**Applicant:** OxTec Developments Limited

**Proposal:** Discharge of Condition 7 (external lights/ floodlights) of 22/02647/F

2.2. The application shows 6 types of lighting shown on Drawing No D47309/PMU/A

Date: 22 September 2022 | Drawing No.: D47309/PMU/A

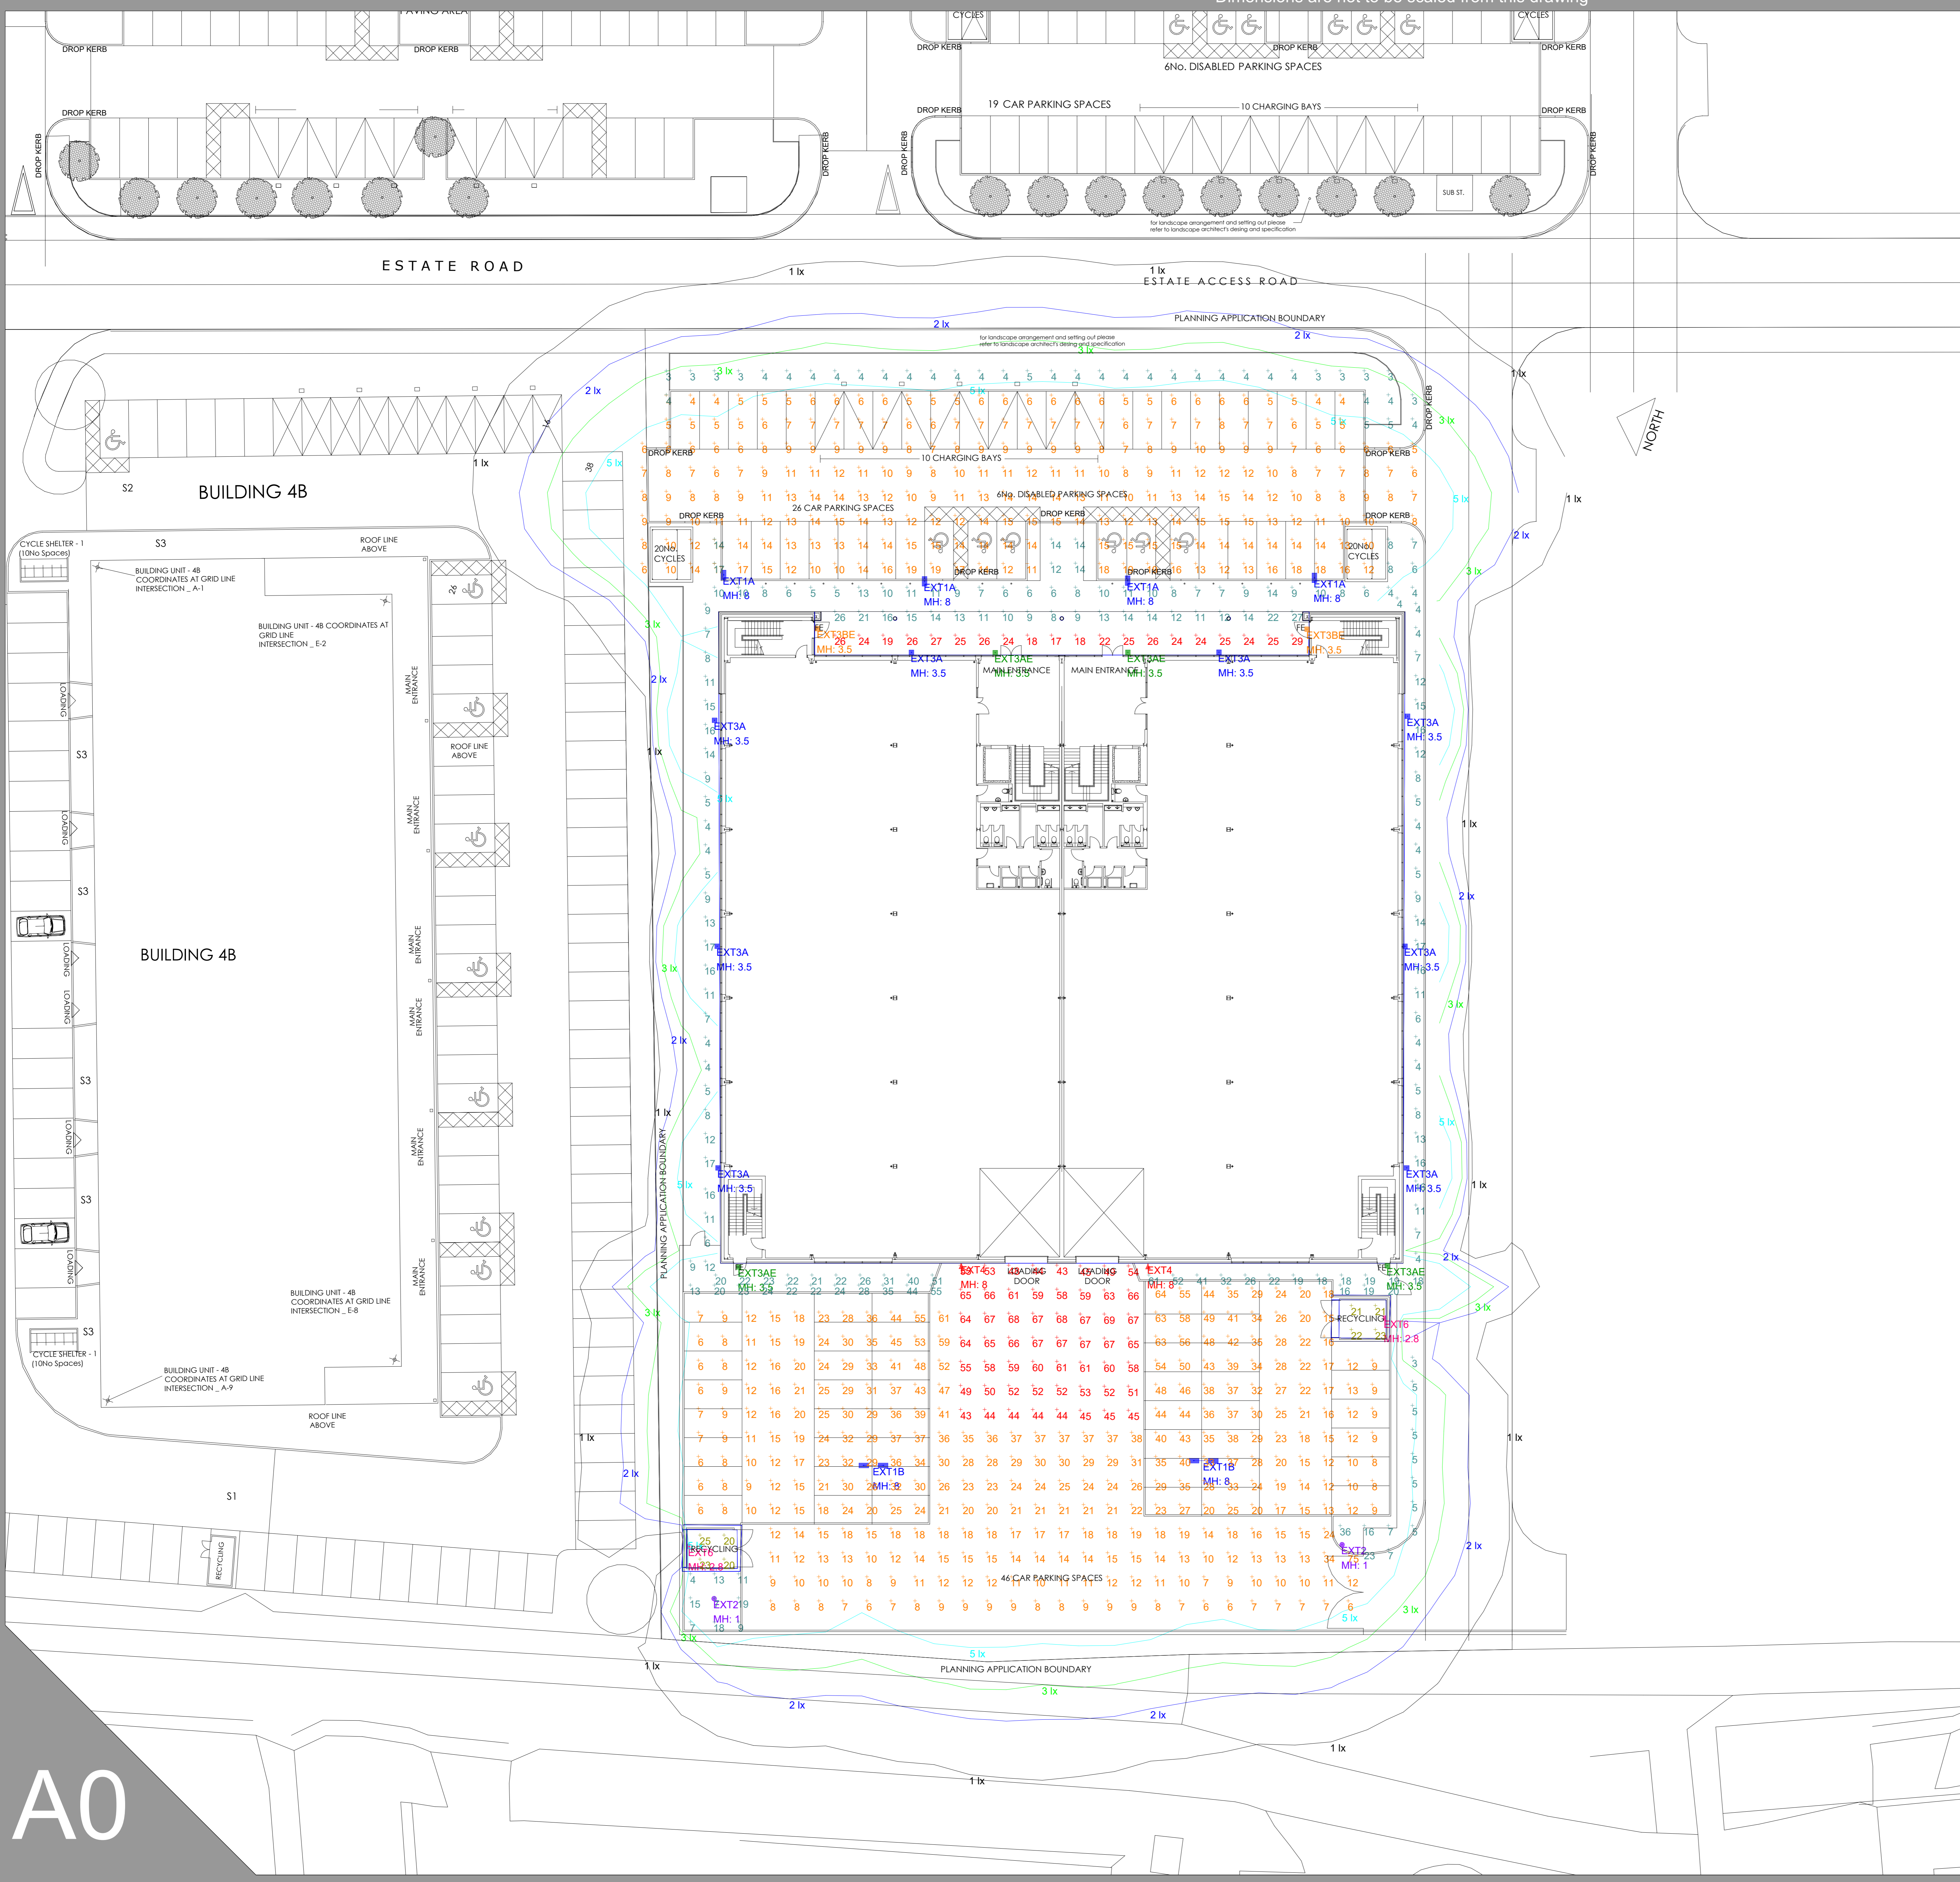
- 4no. 40w LED 4000k (2 module) 700mA Italo 1 with S05 Optic – Mounted on pole at 8m (in a single direction lighting arrangement)
- 2no. 40w LED 4000k (2 module) 700mA Italo 1 with S05 Optic - Mounted on pole at 8m (in a back to back direction lighting arrangement)
- 2no. 7.5w LED 4000k Deco 2,0 1m high bollard
- 14no. 7.5w LED 4000k Quarto 2,0 250mA bulkhead with cycle optic (Wall mounted at 3.5m) (various arrangements)
- 2no 160w LED 4000k Zactis 808mA Floodlight with FW70 Optic (Wall mounted at 8m)
- 2no 20w LED 4000k Alfresco 2,0 bulkhead with hood (Wall mounted at 2.8m)

2.3. The submitted plan shows light spillage from the proposed lighting and that this would not extend beyond the site.

6.1. The proposed lighting would be proportionate to the scale of the building and be commonplace to a commercial setting. The proposed lighting would not result in light pollution or impact on London Oxford Airport as the proposed lighting would be pointed down and light impacts would not go beyond the site. Due to the position of this site, there are no residential receptors in close proximity. It also appears to be comparable to the lighting scheme approved relating to the hotel at the front of the Technology Park site. As such the plan and information submitted is sufficient to discharge the condition subject to its implementation. However the condition remains in place to prevent further lighting being installed.

The information submitted on Drawing No D47309/PMU/A shows six types of lighting. These being:

- 4no. 40w LED 4000k (2 module) 700mA Italo 1 with S05 Optic – Mounted on pole at 8m (in a single direction lighting arrangement)
- 2no. 40w LED 4000k (2 module) 700mA Italo 1 with S05 Optic - Mounted on pole at 8m (in a back to back direction lighting arrangement)
- 2no. 7.5w LED 4000k Deco 2,0 1m high bollard
- 14no. 7.5w LED 4000k Quarto 2,0 250mA bulkhead with cycle optic (Wall mounted at 3.5m) (various arrangements)
- 2no 160w LED 4000k Zactis 808mA Floodlight with FW70 Optic (Wall mounted at 8m)
- 2no 20w LED 4000k Alfresco 2,0 bulkhead with hood (Wall mounted at 2.8m)

The information submitted shows lighting pointed downward and with light spillage not exceeding the site. As such subject to the implementation of the lighting in accordance with this plan, the scheme would be acceptable in respect of the condition. However the condition remains in place to prevent further lighting being installed without the prior express consent of the Local Planning Authority.
